**Our ref:** KT/2018/124583/02-L01  
**Your ref:** EN010084  
**ID:** 20012595  
**Date:** 15 January 2019

**Application for a Development Consent Order - Thanet Extension Offshore Wind Farm**

- **Written Representations on behalf of the Environment Agency**
- **Response to the Examiners Written Questions**
- **Statement of Common Ground – The Applicant and the Environment Agency**

Figure 1.11: Indicative Option 2 landfall layout (plan view).

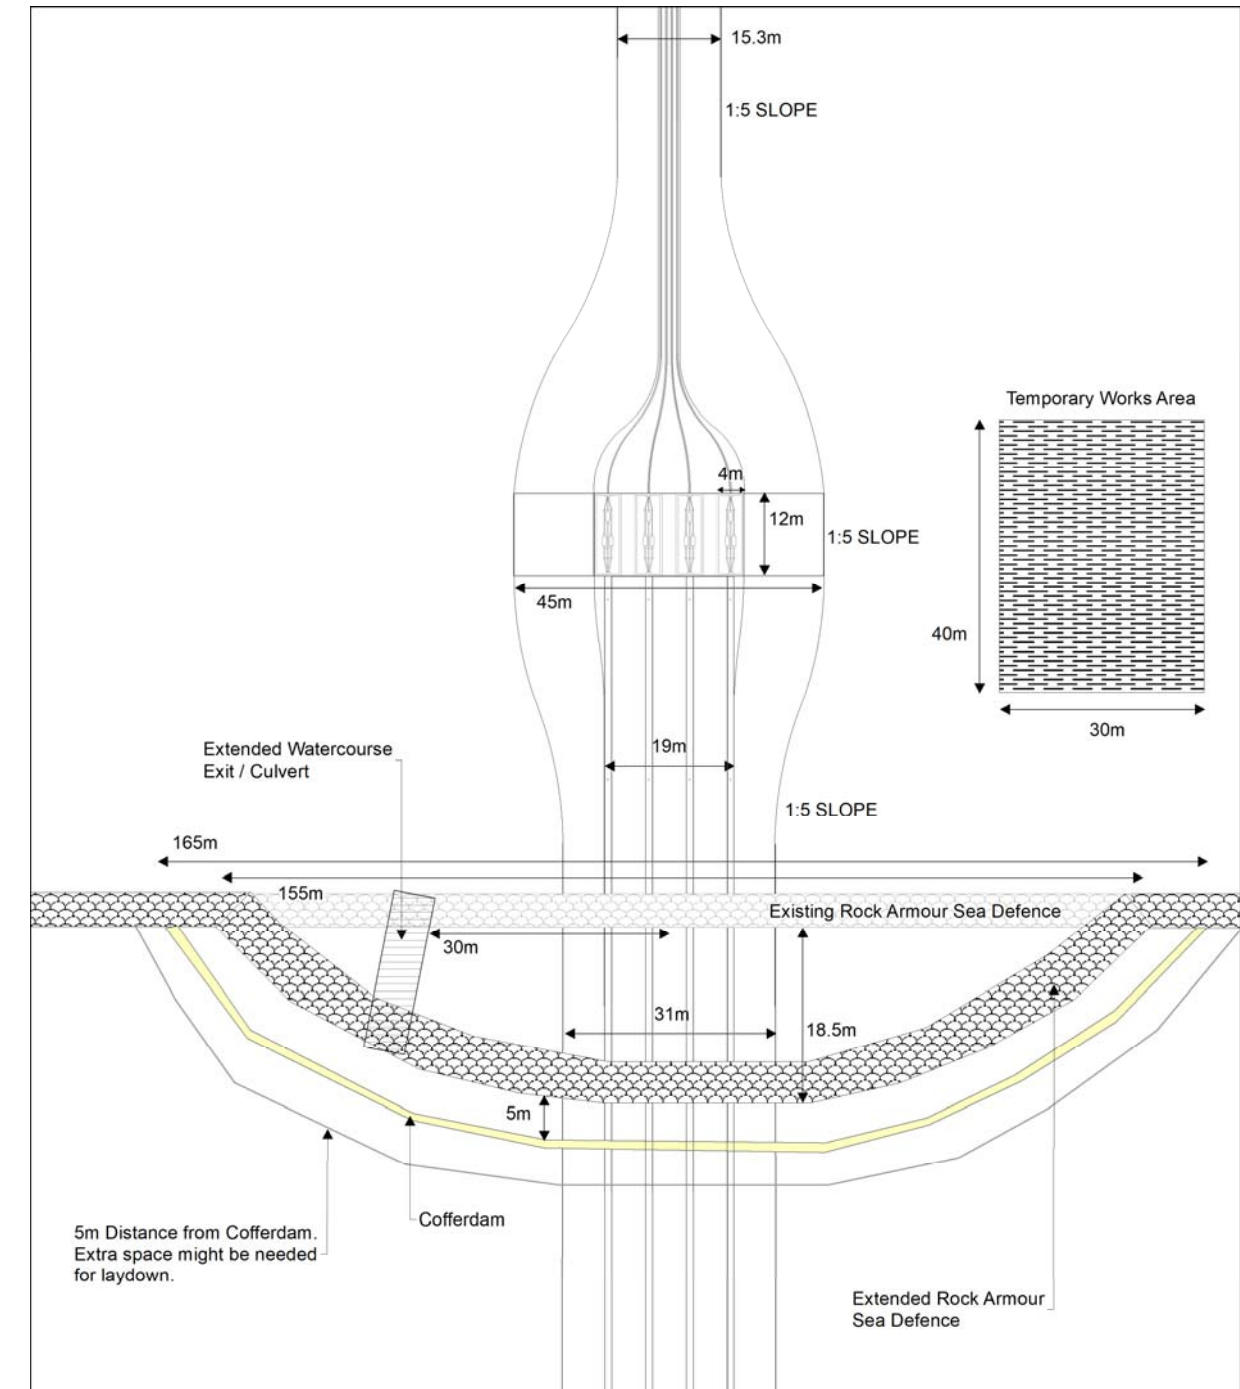
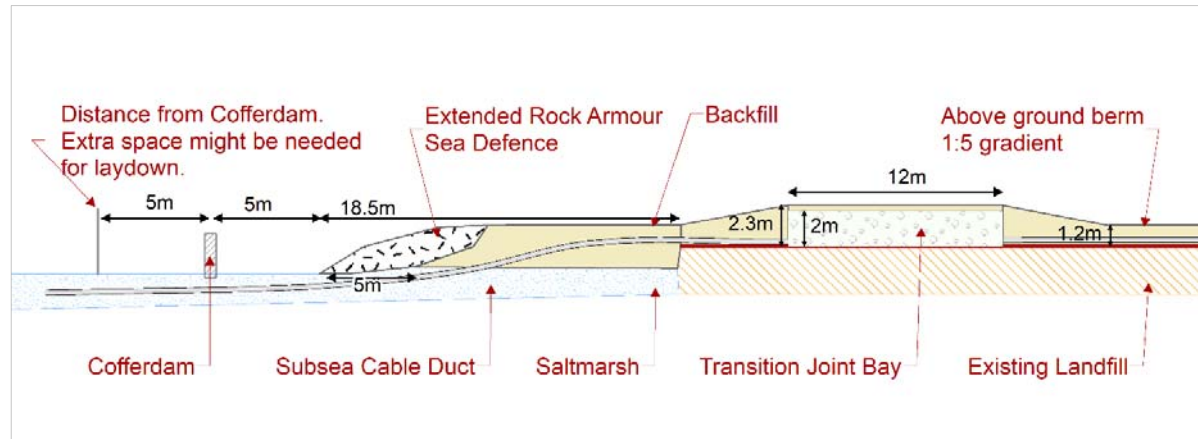
**Amended Comment:** **Option 2** was the potentially the most damaging of all and could result in permanent fragmentation of a regionally important habitat. We support the removal of option 2 from the application.
